**WELWYN HATFIELD BOROUGH COUNCIL
ASSISTANT DIRECTOR (PLANNING)**

DELEGATED APPLICATION

Application No: 6/2022/2914/FULL
Location: 5 West View Hatfield AL10 0PJ
Proposal: Retention of a temporary management office to the rear of the property for a period of 12 months
Officer: Ms Elizabeth Mugova

Recommendation: Refused

Proposed Block Plan 1:500

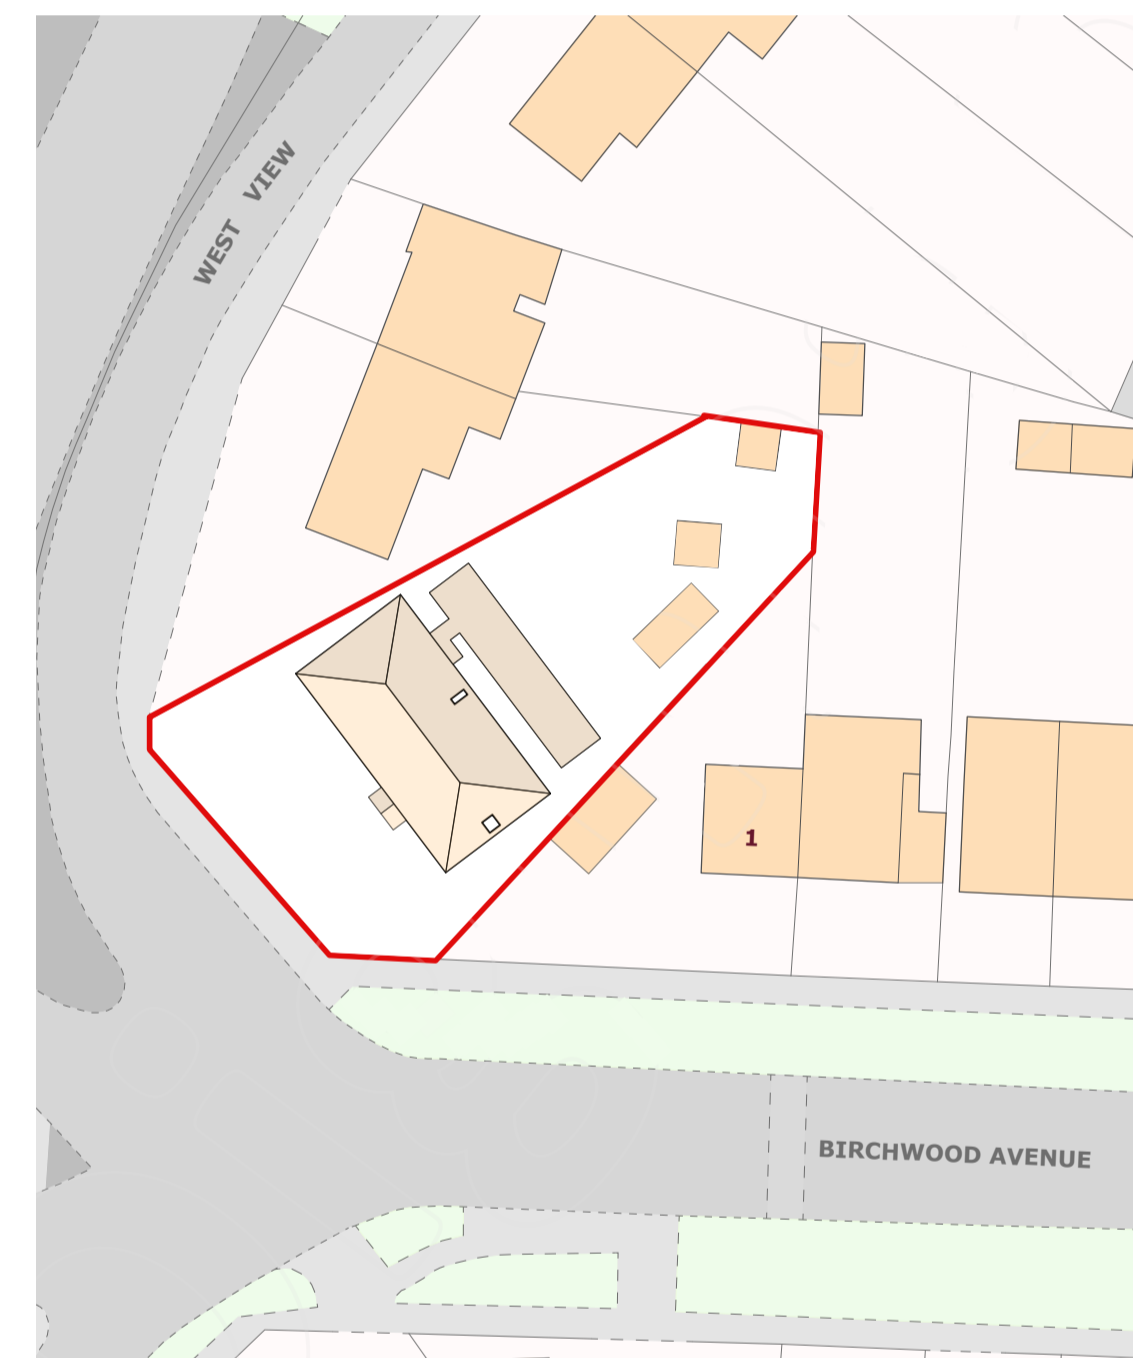
<p>The outbuilding is single storey with a footprint of approximately 45m². Although the outbuilding is slightly set in within the rear elevation of the host building, views of the outbuilding are partially visible from the streetscene. The rear ground floor of the host building features a bay window, the outbuilding is sited approximately 0.8-2m from the rear elevation. Given the size and siting of the outbuilding, it is considered that the proposal is a disproportionate addition to the rear elevation of the host building, resulting in cramped development when viewed from the rear. As such, it is considered that the retention of the outbuilding would result in significant harm to the character and appearance of the host building and surrounding area.</p> <p>Considering that application 6/2023/0456/FULL has not yet been approved, the need for the management office is not temporary. In addition, it is considered that the harm posed to the character and appearance of the application site and surrounding area is not overcome by the temporary time period of the permission sought.</p> <p>As highlighted above, application 6/2023/0456/FULL is still under consideration, it is considered that if both schemes were submitted as one application, the cumulative impact from the proposal would give rise to a substantial level of visual clutter and cramped development that would significantly harm the character and appearance of the site and surrounding area.</p> <p>As a consequence of the above, it is considered that the outbuilding is a disproportionate addition to the rear elevation of the host building, resulting in a cramped development when viewed from the rear. Consequently, the proposal appears incongruous and visually intrusive leading to unacceptable harm to the character and appearance of the surrounding area. Accordingly, it is considered that the proposal represents a poor standard of design contrary to District Plan Policies D1, D2 and GBSP2; Policy SP9 of the Draft Local Plan; the Supplementary Design Guidance; and the National Planning Policy Framework.</p>

Client: Group PA
Site Address: 5 West View
AL10 0PJ
Drawing Number: 001
Scale: 1:100
Project: Development

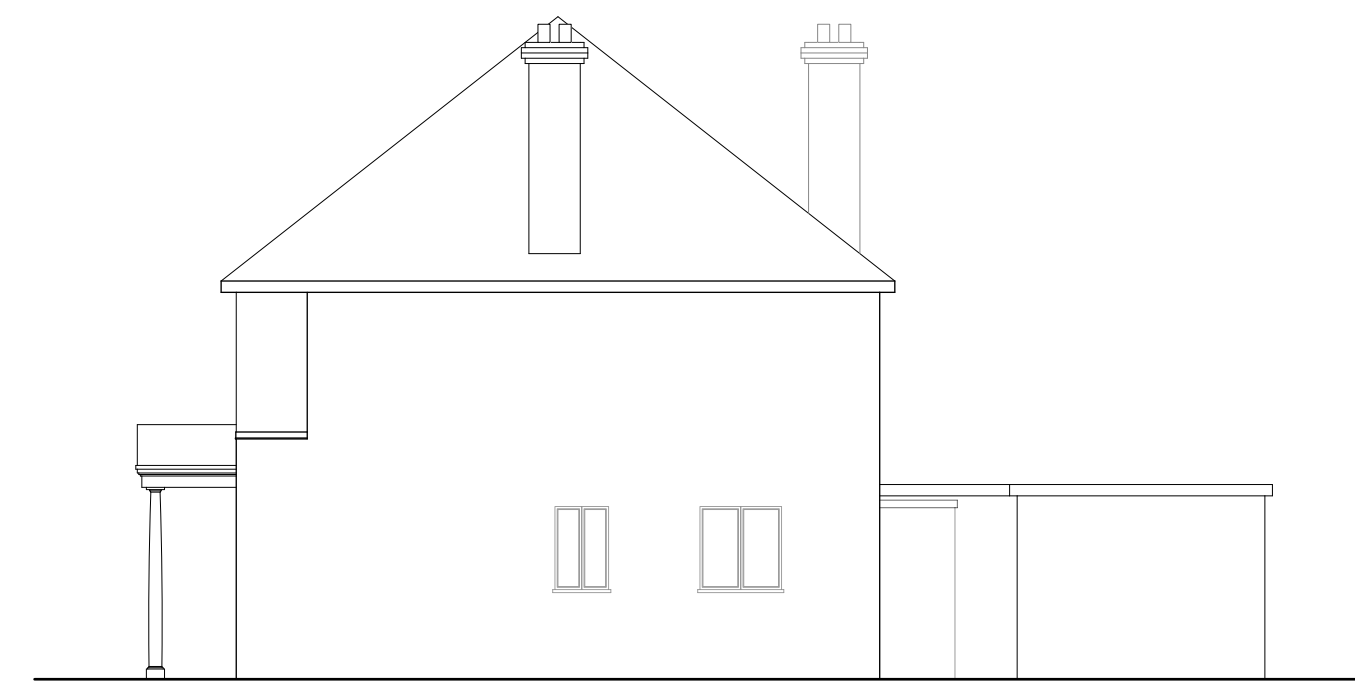
1. The proposed retention of the unlawful outbuilding, by virtue of its siting, size and scale, would regularise what is a disproportionate addition to the rear elevation that fails to respond positively to the host property, resulting in a cramped development when viewed. Consequently, the proposal would result in significant harm to the character and appearance of the host building and surrounding area. Accordingly, it is considered that the proposed development represents a poor standard of design in conflict with District Plan Policies D1, D2 and GBSP2; Policy SP9 of the Draft Local Plan; the Supplementary Design Guidance; and the National Planning Policy Framework.

Client: Group PA
Site Address: 5 West View
AL10 0PJ
Drawing Number: 003
Scale: 1:100
Project: Development

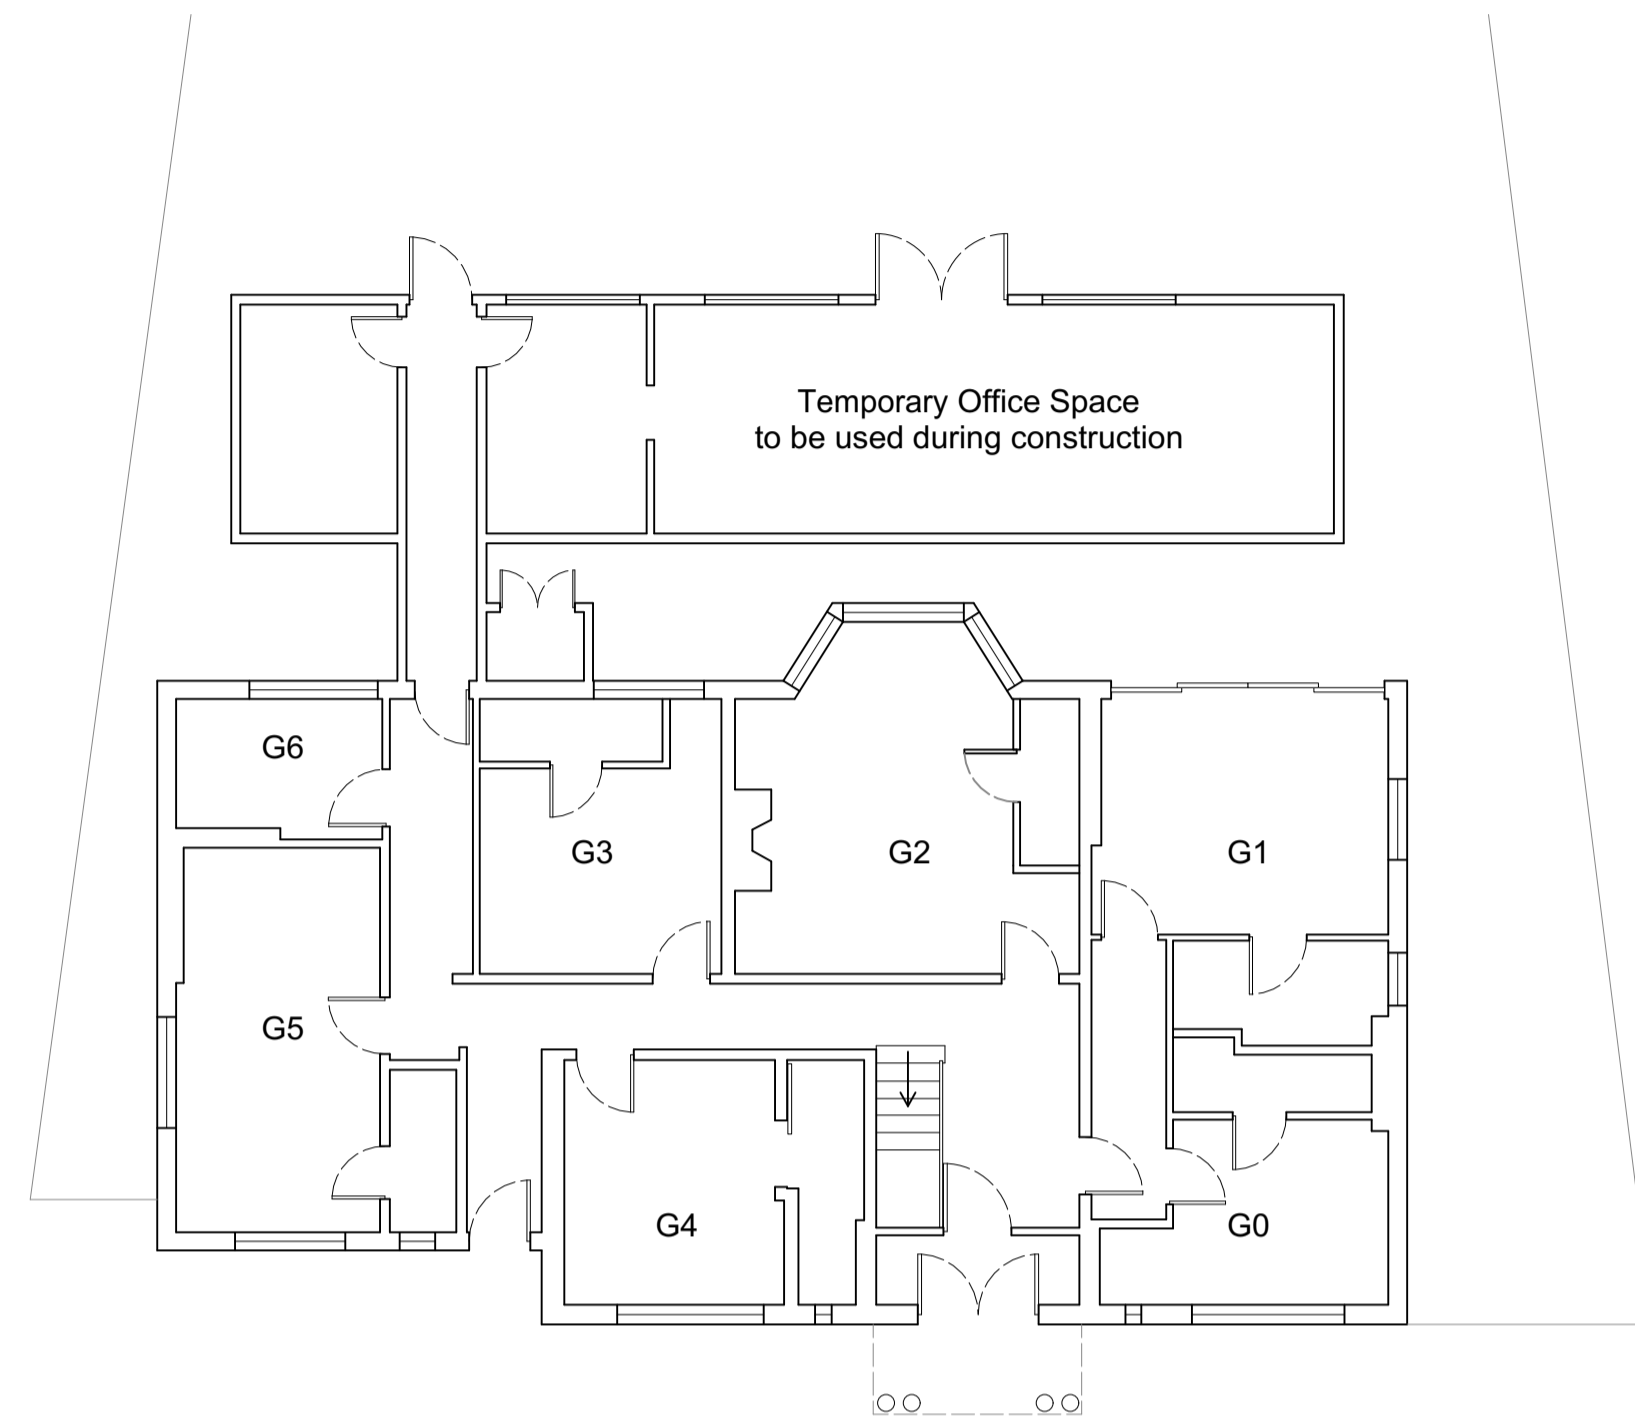
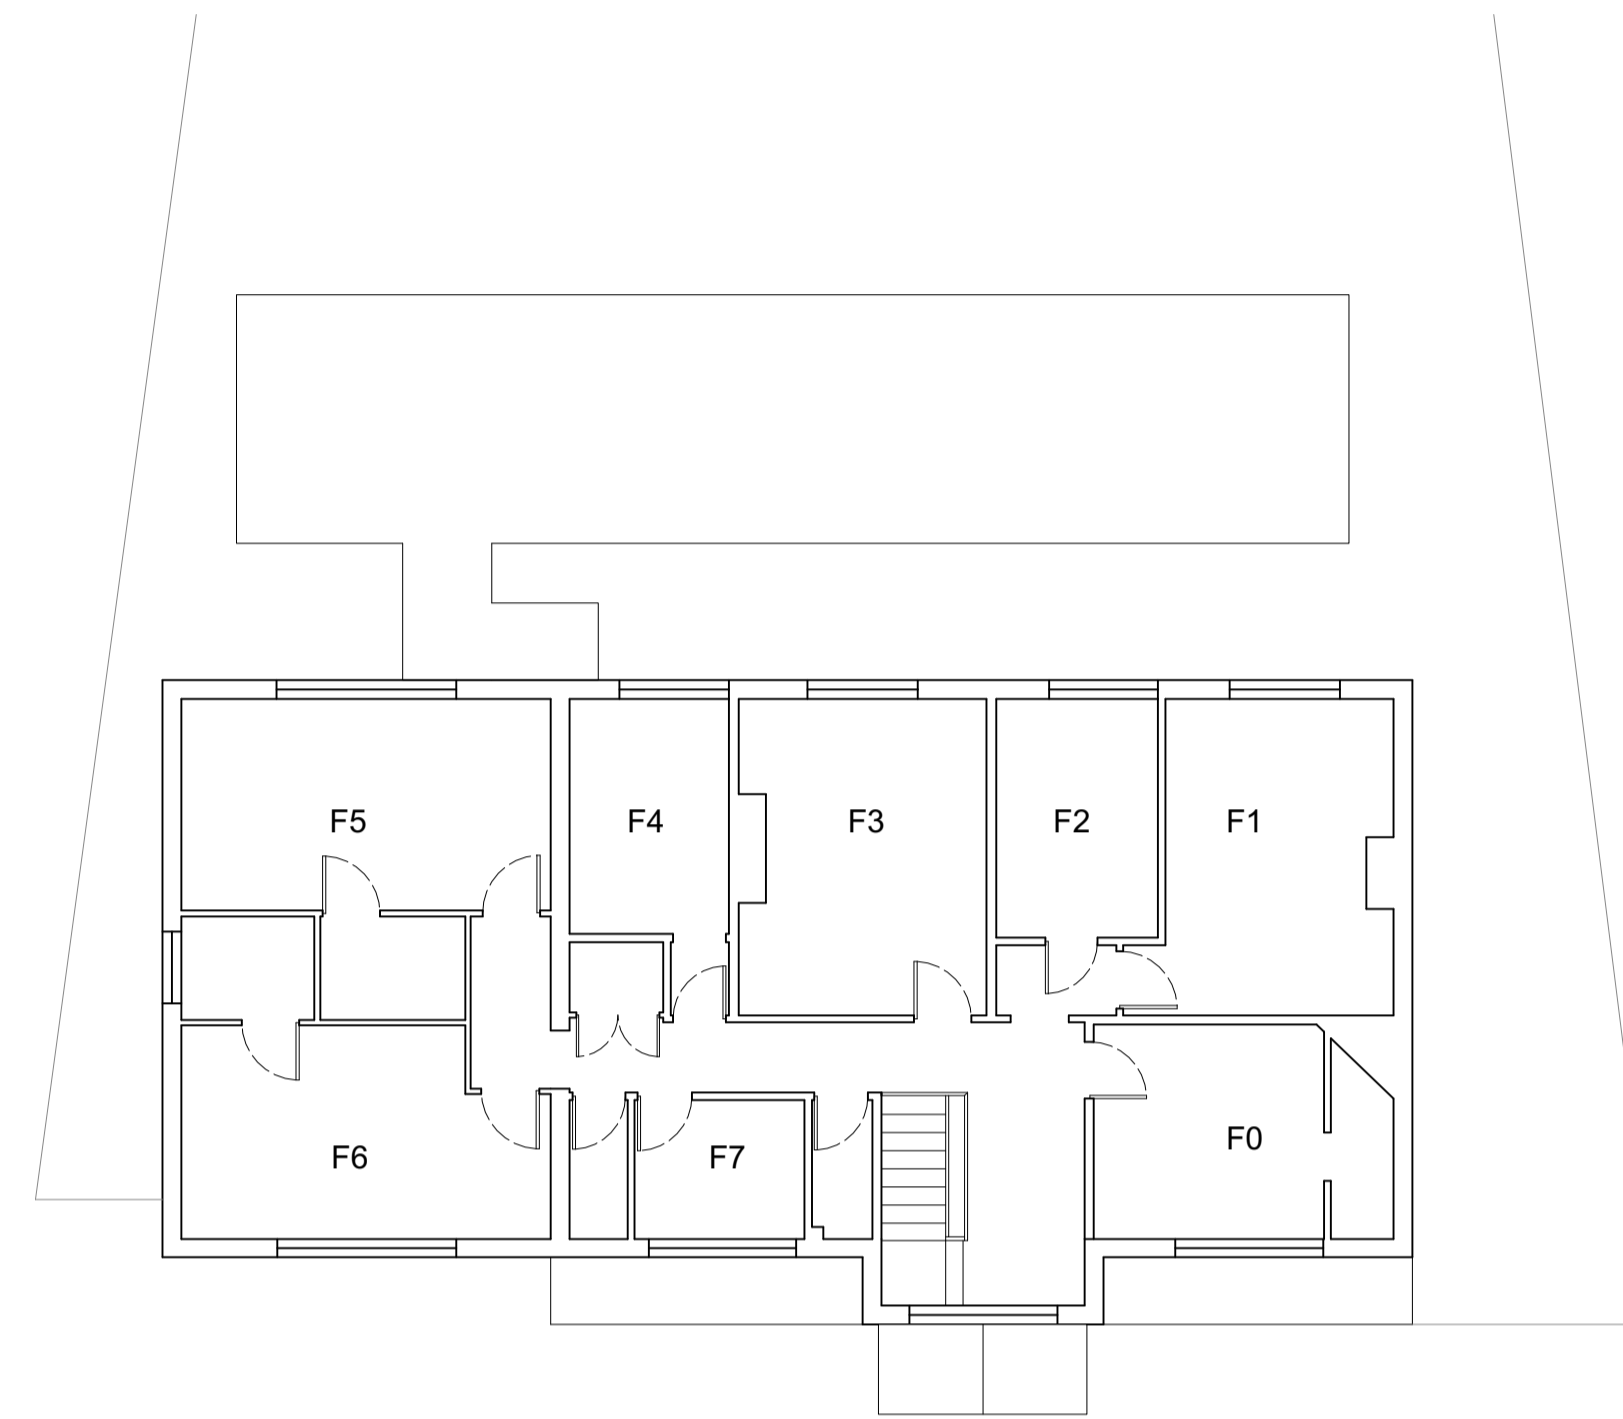
<p>Impact on neighbours</p>	<p>Policy D1 and the Supplementary Design Guidance (SDG 2005) provide the local policy framework for assessing the impact of development on the residential amenity and living conditions of neighbouring properties. This is assessed in terms of day and sun light, overbearing impact and overlooking/loss of privacy. Policy SADM11 of the Draft Local Plan is similar in these aims.</p> <p>The most likely neighbours to be impacted are those at No 1 Birchwood Avenue and No 6 West View.</p> <p>The objection from No 1 Birchwood Avenue is acknowledged.</p> <p><u>Living conditions of neighbouring occupiers</u> Due to the siting and single storey nature of the outbuilding, it is considered that the proposal would not impact on the amenity of the adjoining occupiers.</p> <p><u>Current occupiers</u> Due to the siting of the outbuilding, the proposal would limit the amount of light to the four ground floor rooms. In addition, the proposal would result in poor outlook to the guest house users. As such, it is considered that the proposal</p>

<p>would result in poor quality living conditions to the users of the guest house.</p> <p>As a consequence of the above, it is considered that the proposal would have an unacceptable impact on the living conditions of guest house users due to loss of light and poor outlook, contrary to Policy D1 of the Welwyn Hatfield District Plan, Policy SADM11 of the Welwyn Hatfield Draft Local Plan 2016, the Welwyn Hatfield Supplementary Design Guidance 2005 and the National Planning Policy Framework.</p>
Access, car parking and highway considerations	The outbuilding would be used as a management office and storage of building materials during construction of the proposed rear outbuildings. It is considered that the proposal would not intensify the existing use, thereby not warranting any further parking provision.
Conclusion	
For the reasons set out above, the development does not accord with the relevant policies, thus is not acceptable in terms of design and character. It is therefore recommended that planning permission is refused.

2. By virtue of its siting, close to the host building, the proposed retention of the outbuilding would result in adverse harm to the amenity of rear ground floor guest house by way of loss of light and poor outlook, contrary to Policy D1 of the Welwyn Hatfield District Plan 2005; Draft Local Plan Policies SADM11; the Supplementary Design Guidance; and the National Planning Policy Framework.
